Re: *The Townhomes at Bradley Crossroads Rezone (P-18-3) Review 1*
Project No. 601093

M.V.E., Inc. has prepared the following response to comments contained in your July 23, 2018 comment letter concerning the above named project. Revised submittal materials are enclosed as needed. Each comment is addressed below in the order contained in your comment letter.

**ZONING MAP
LOT 1A**

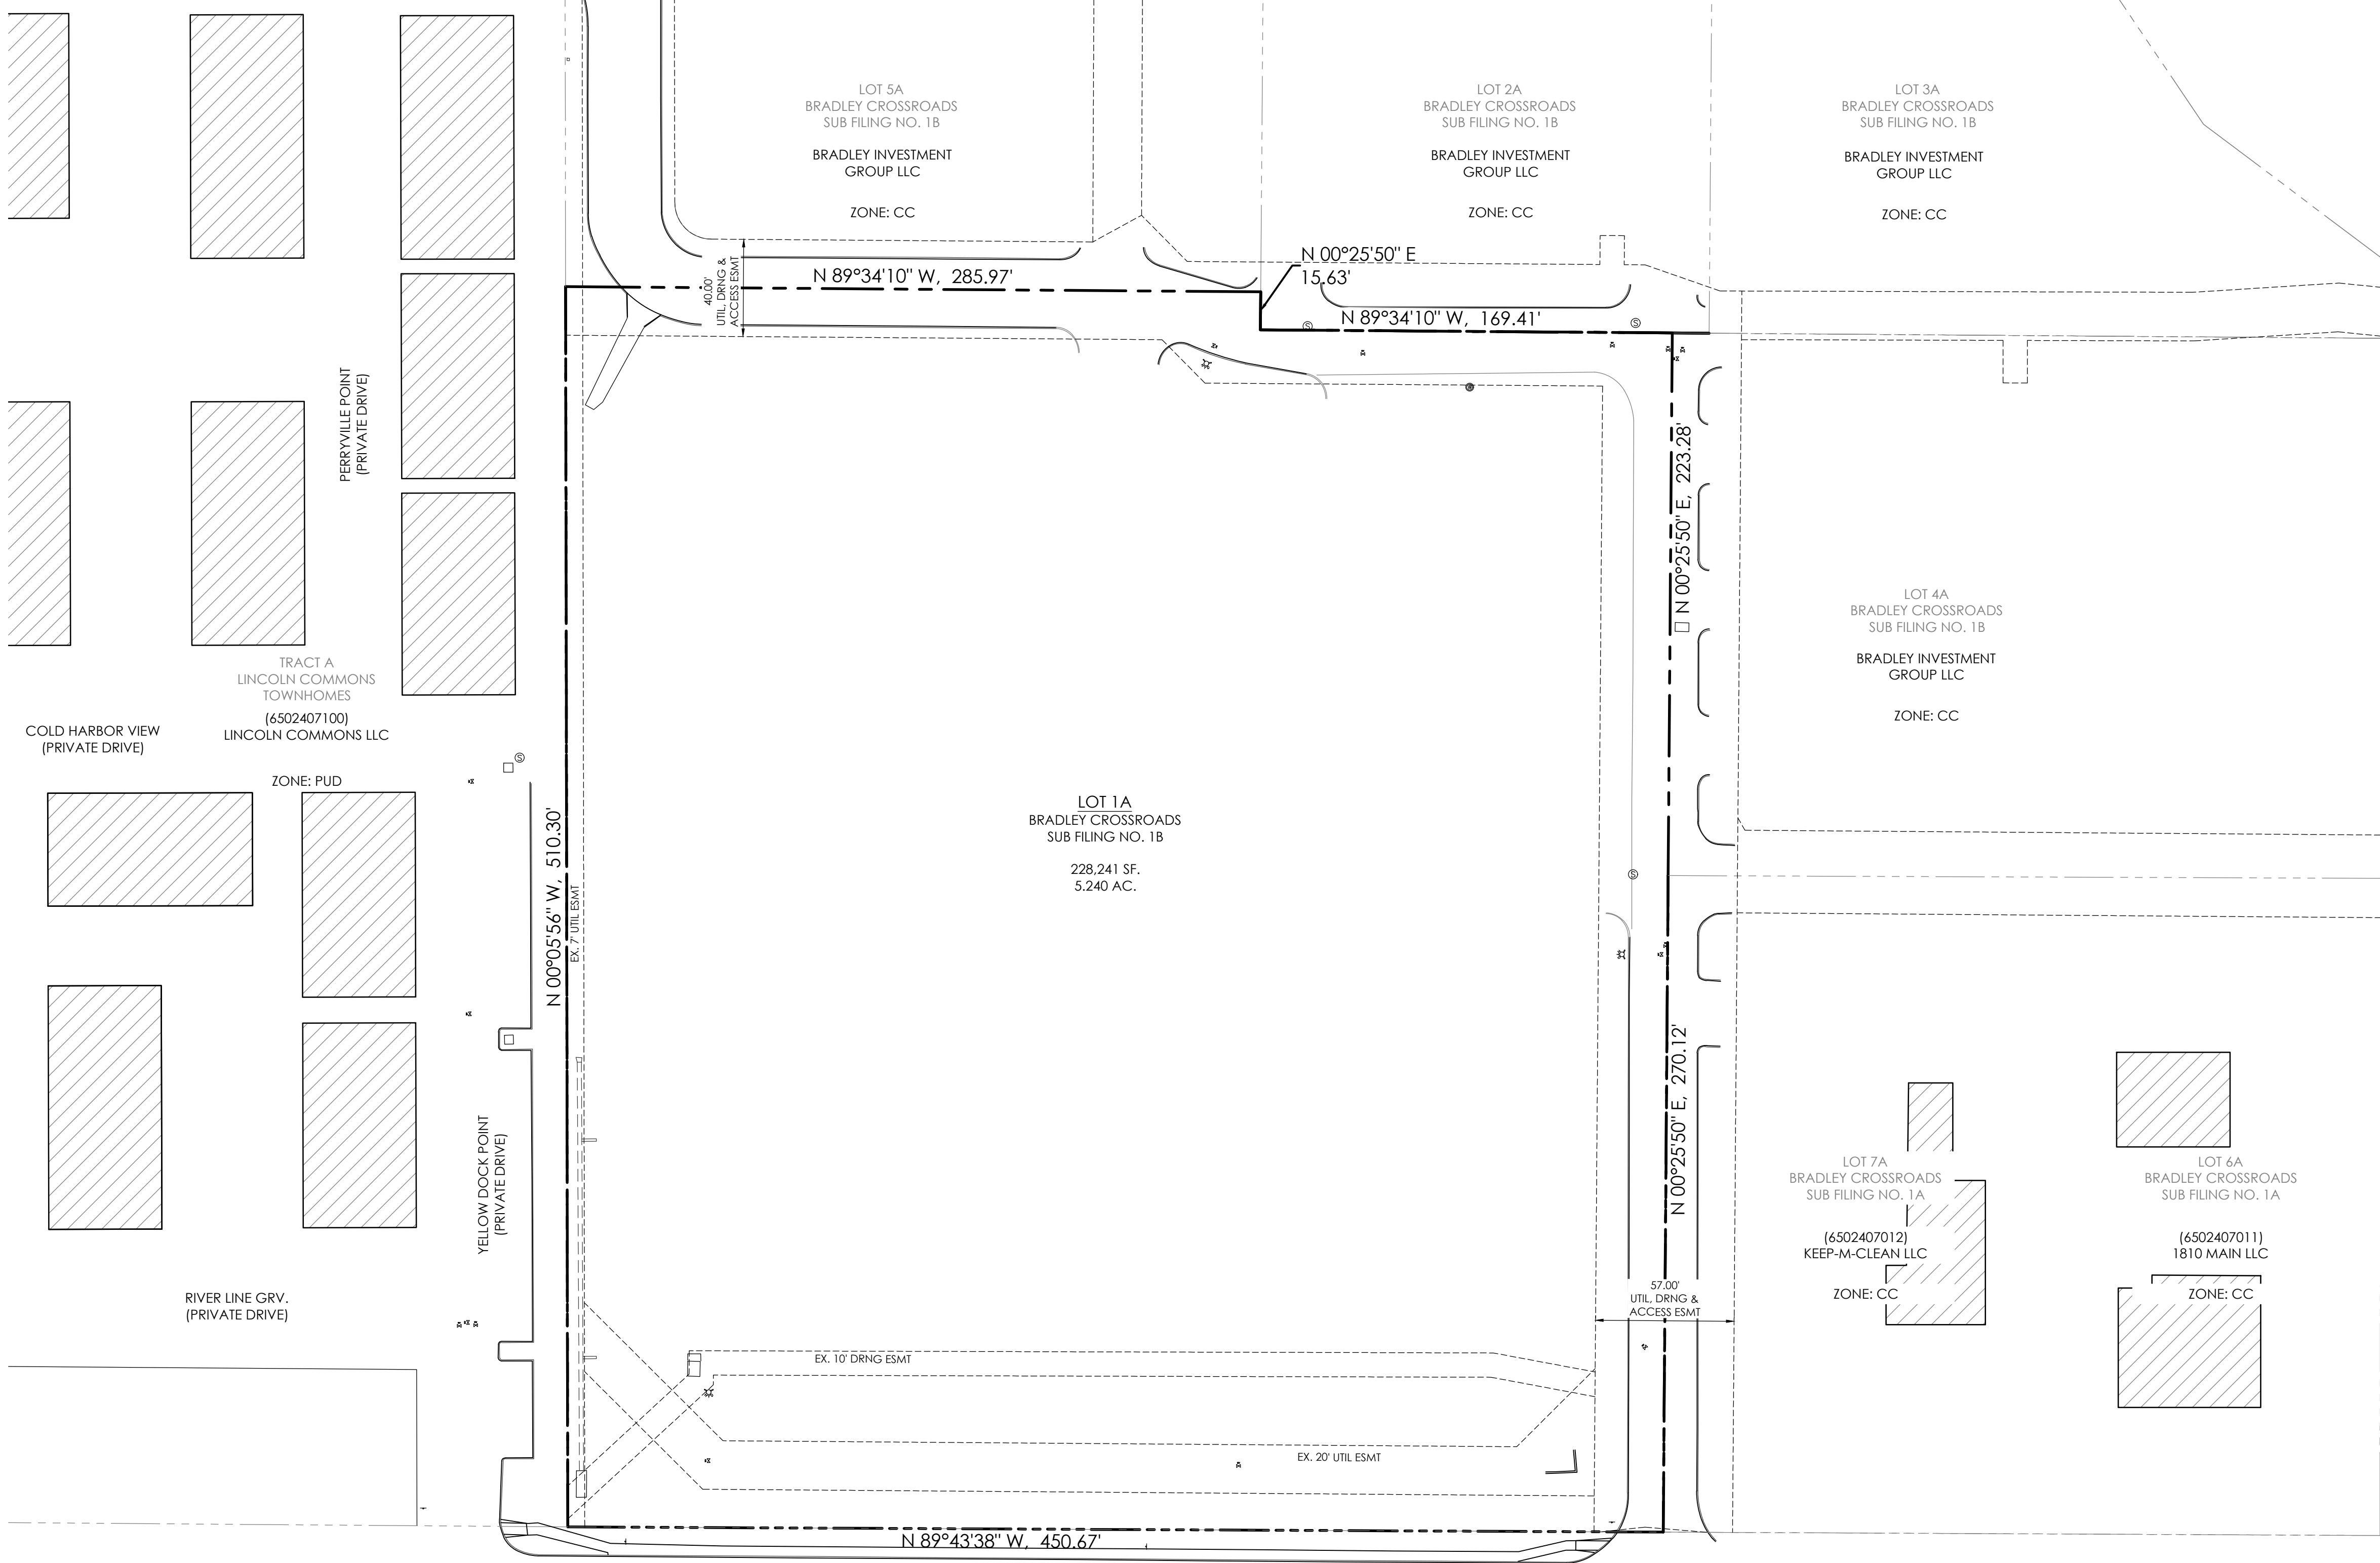
See redlines for the letter of intent and zone map. Response: Redline Comments to the letter of intent and zone map have been addressed on the revised submitted documents.
